CITY OF ALBUQUERQUE

Re: Blue Sky Business Park Drainage Report
Engineer's Stamp dated 7-18-05 (D-16/D2A)

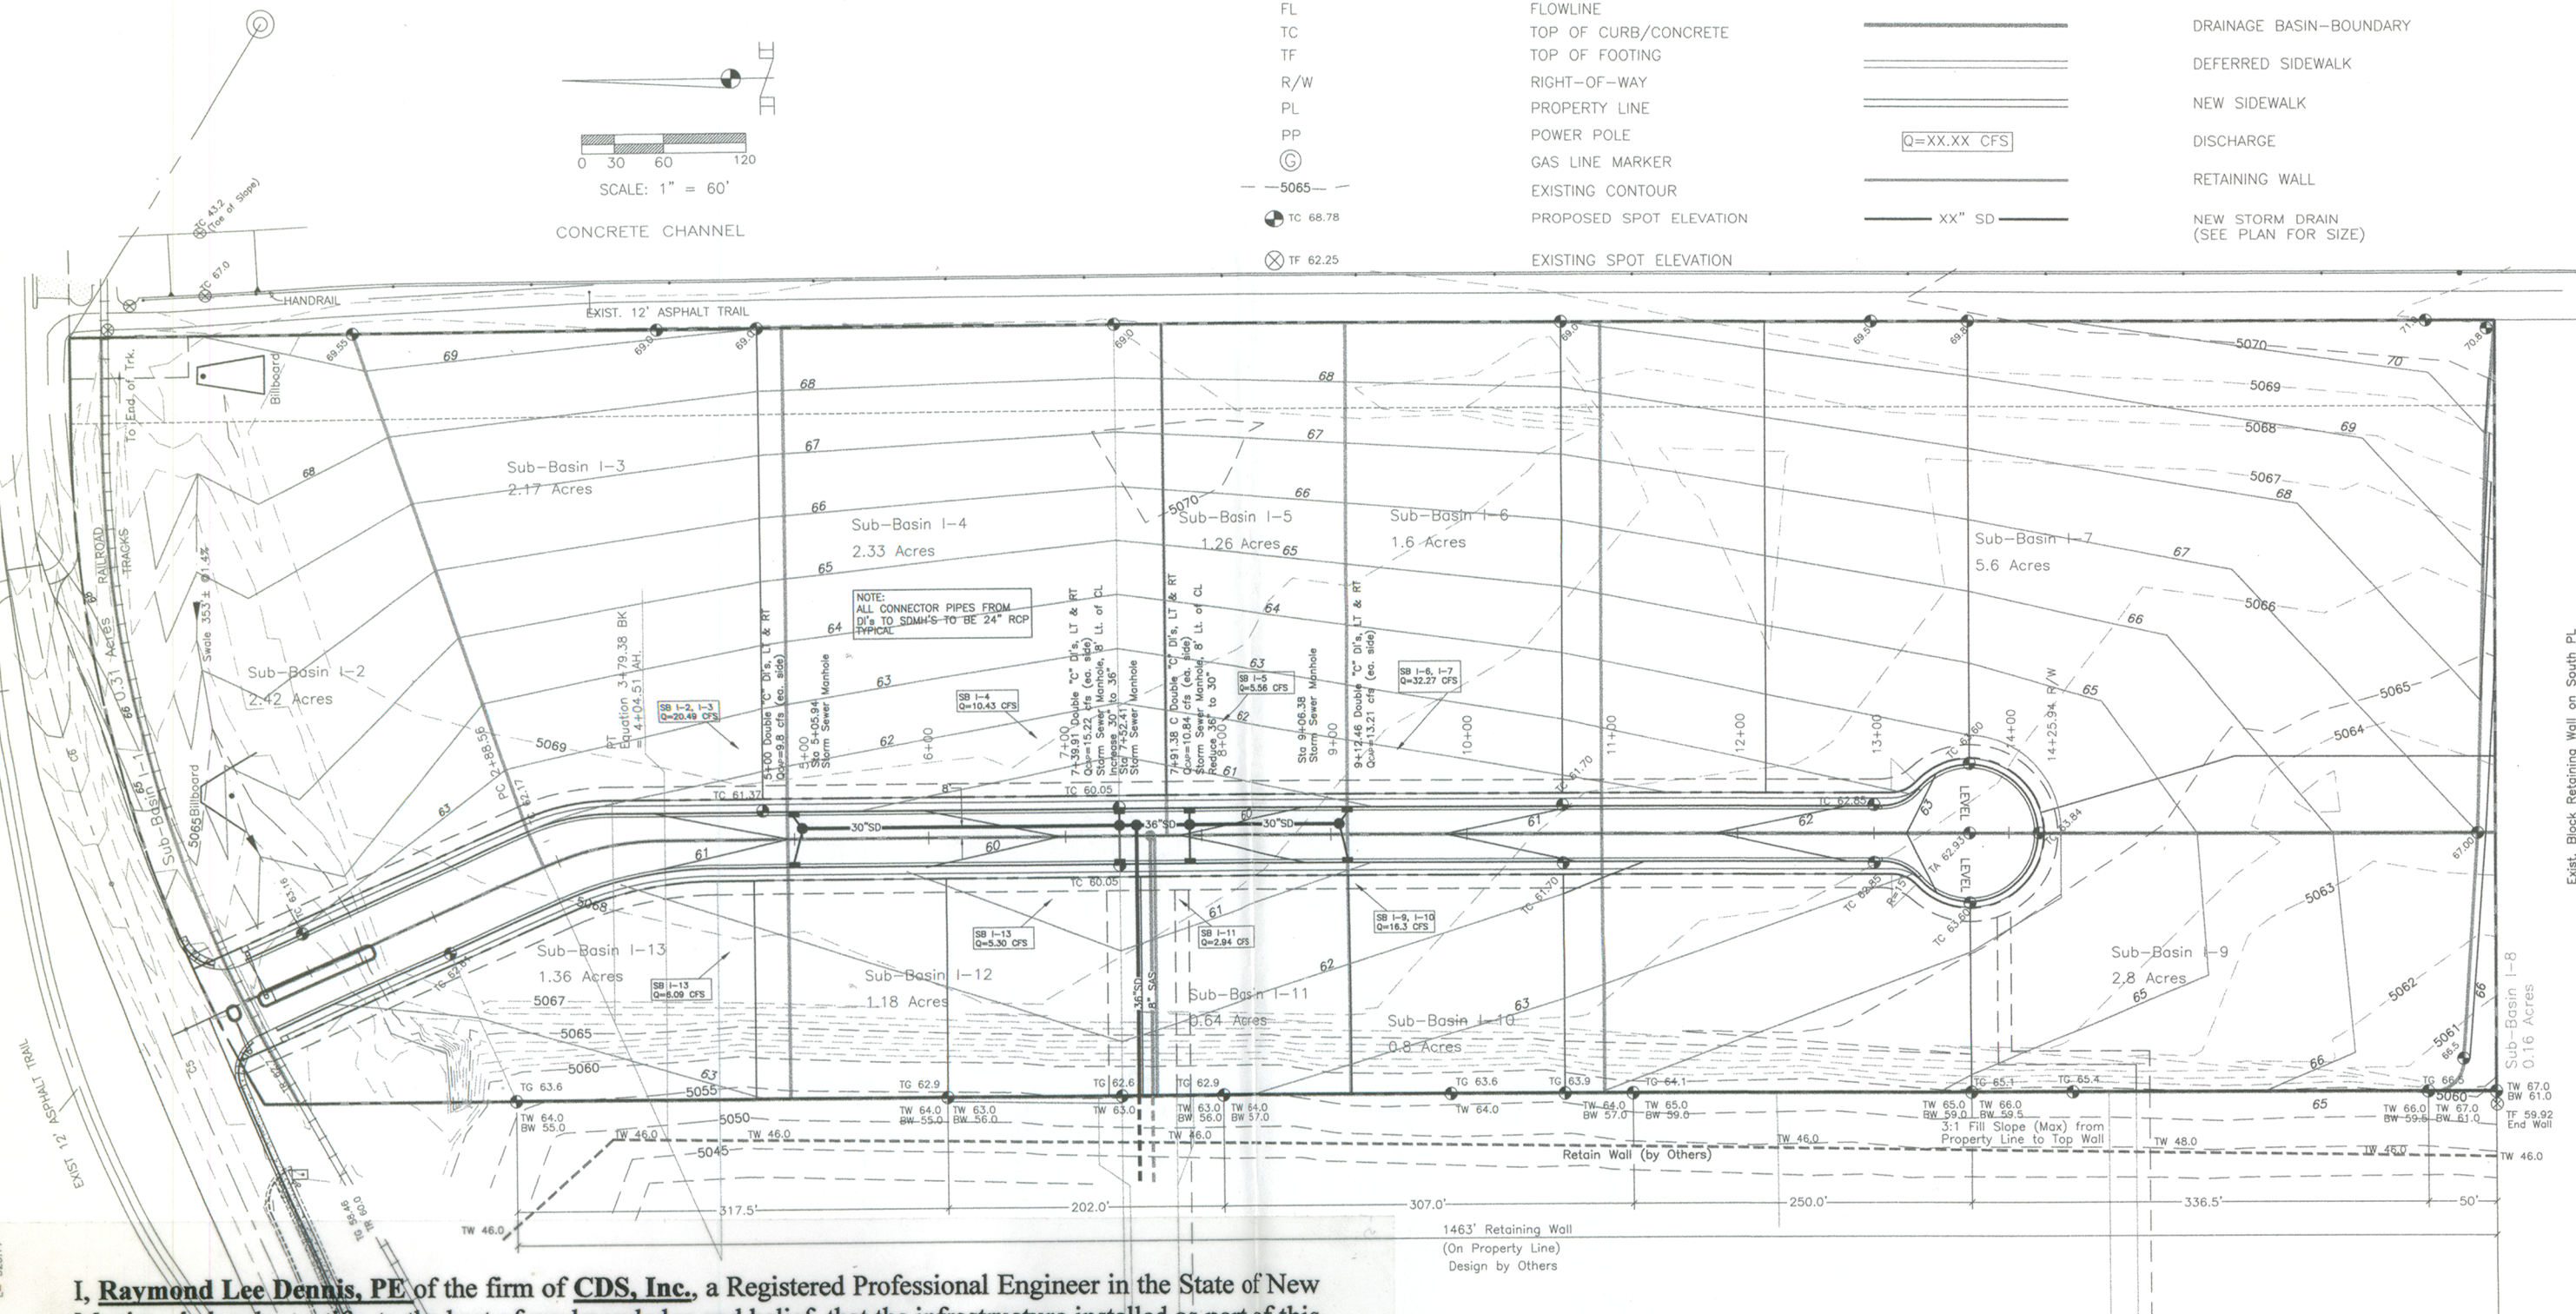
- Every drainage submittal to the City should stand on its own merit. In other words, your narrative should also state that this project routes through the Las Lomas Industrial Park (D16/D2A) project and then to the Vista del Norte North pond (which is being expanded to handle the runoff from Tract T-4). Usually excerpts from *that* plan should be included with yours but updating your narrative will suffice.
